**Consultation Response from KC,
Highways Development Management****2023/92695 Crown Buildings, Scott Hill, Clayton West, Huddersfield, HD8 9PE****Change of use and alterations to workshop to create two dwellings****Date Responded: 31-10-2023.****Responding Officer: Mark Berry****Responding Ref: 17-39-13.**

This application seeks approval to the change of use and alterations to workshop to create two dwellings at Crown Buildings, Scott Hill, Clayton West, Huddersfield.

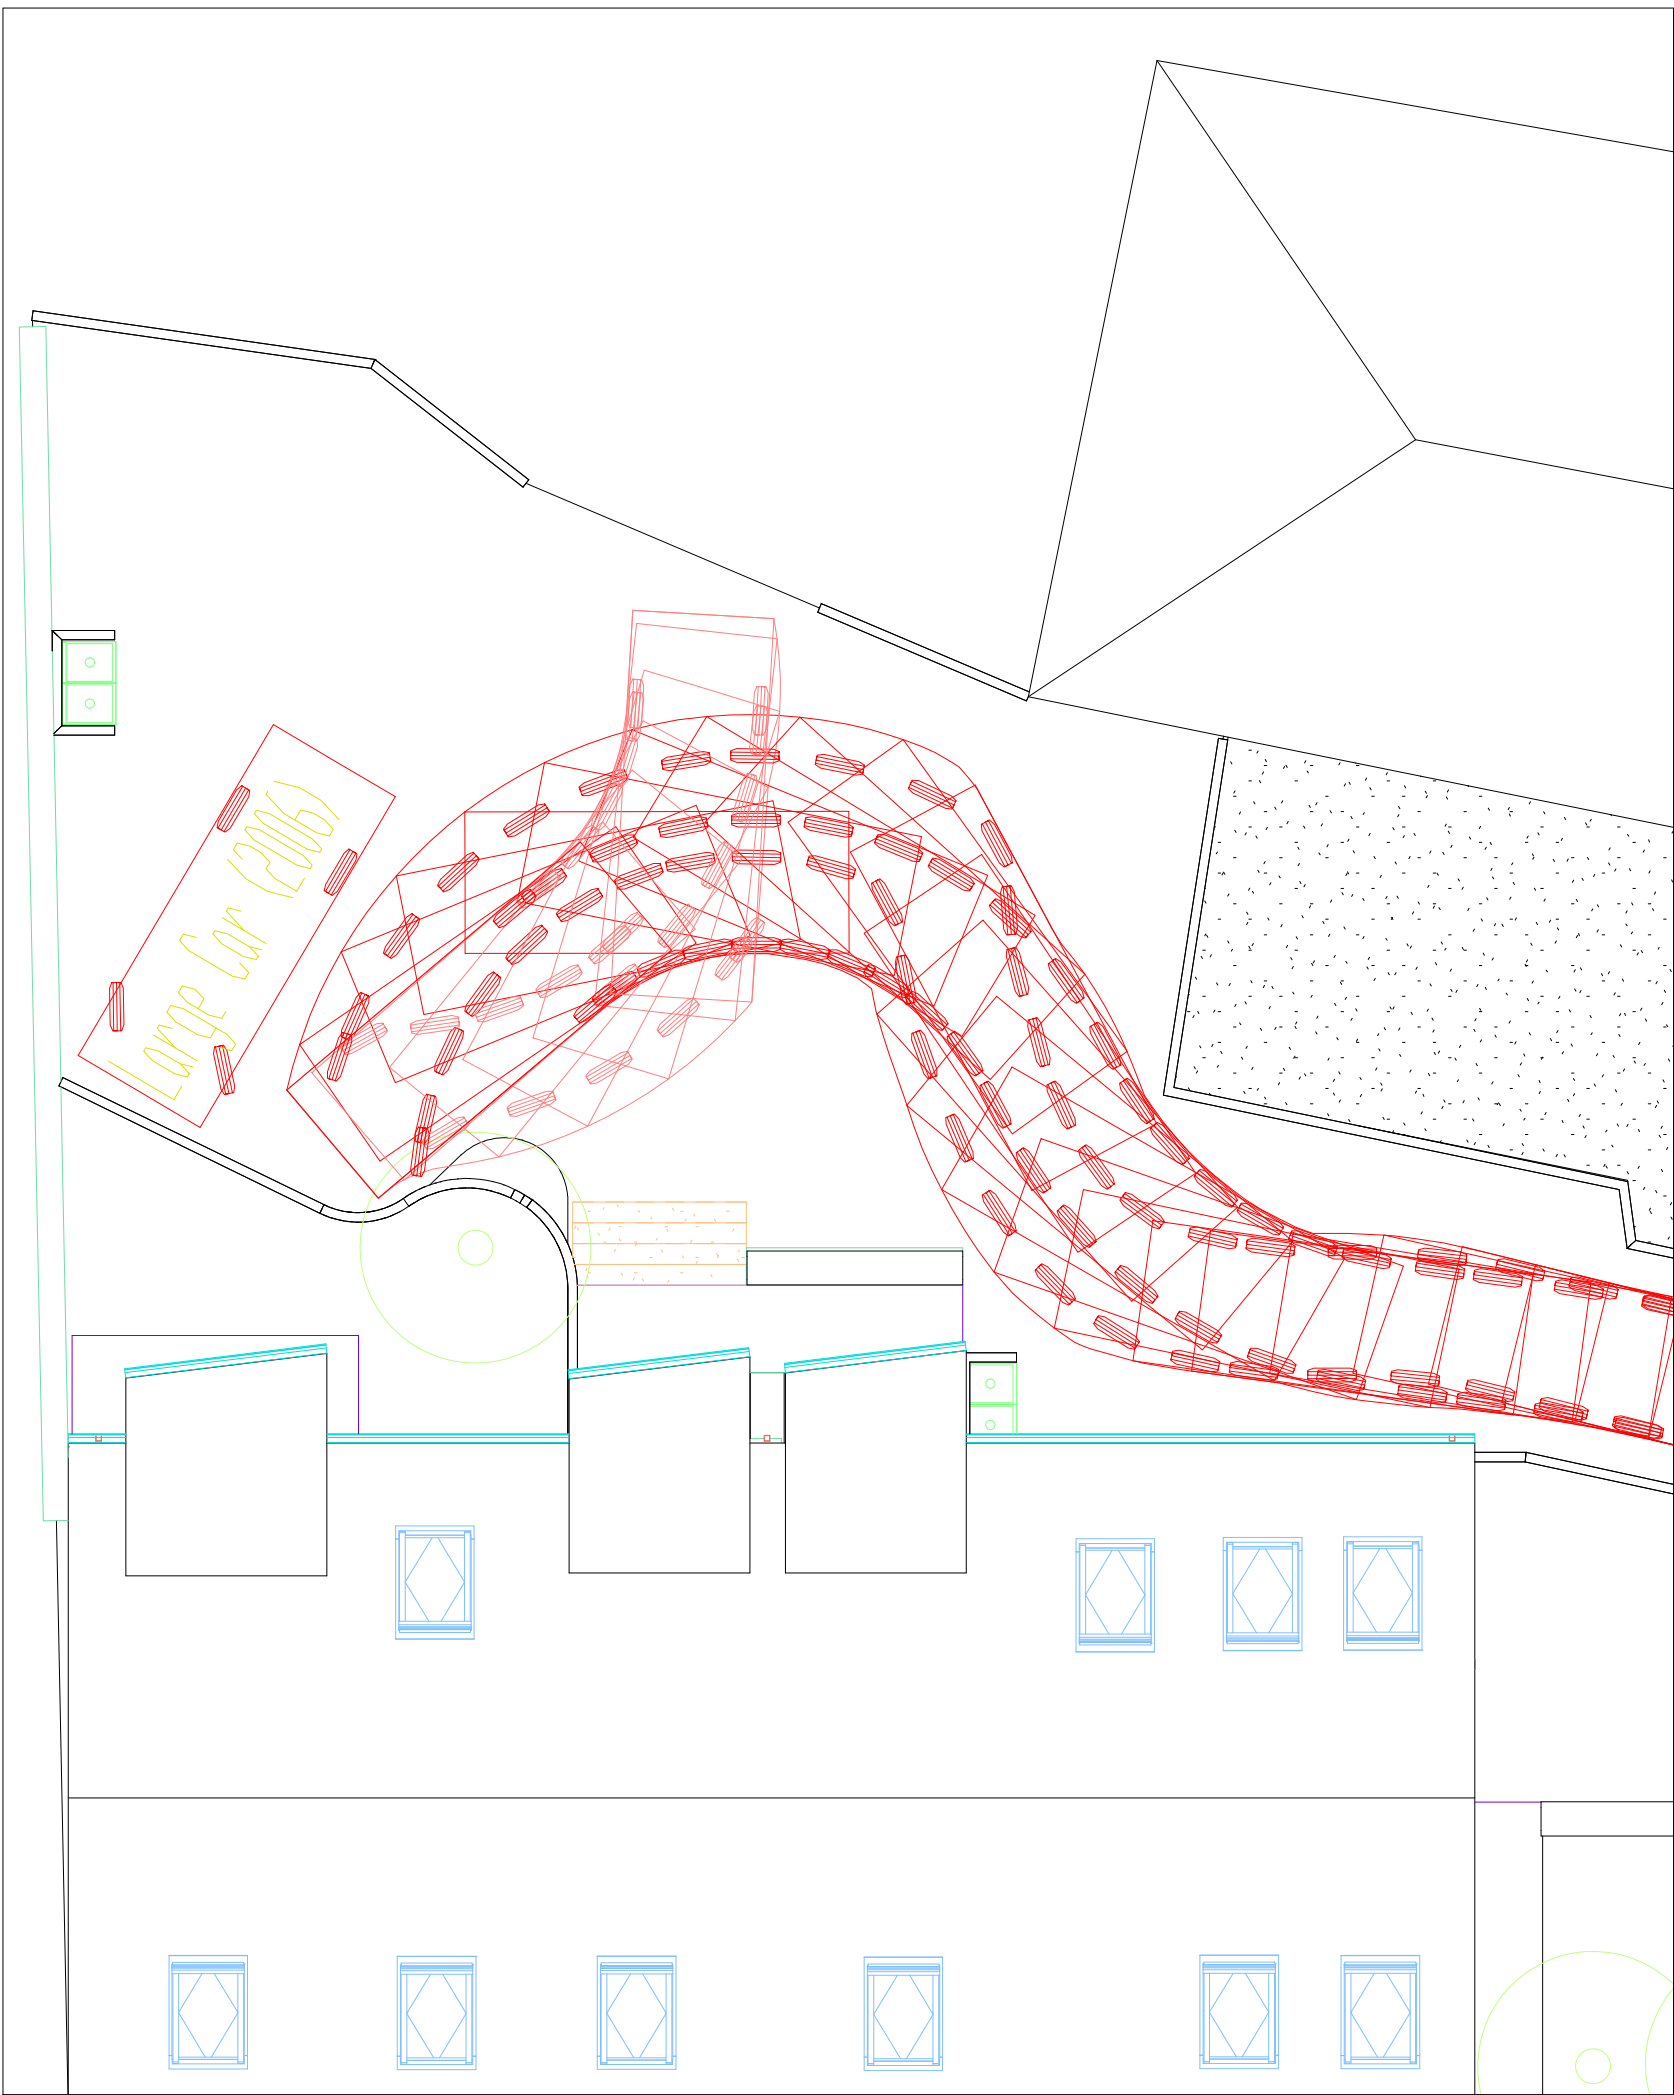
3, Swept paths should be provided which demonstrate that a vehicle can enter and exit the site in a forward gear from Scout Hill.
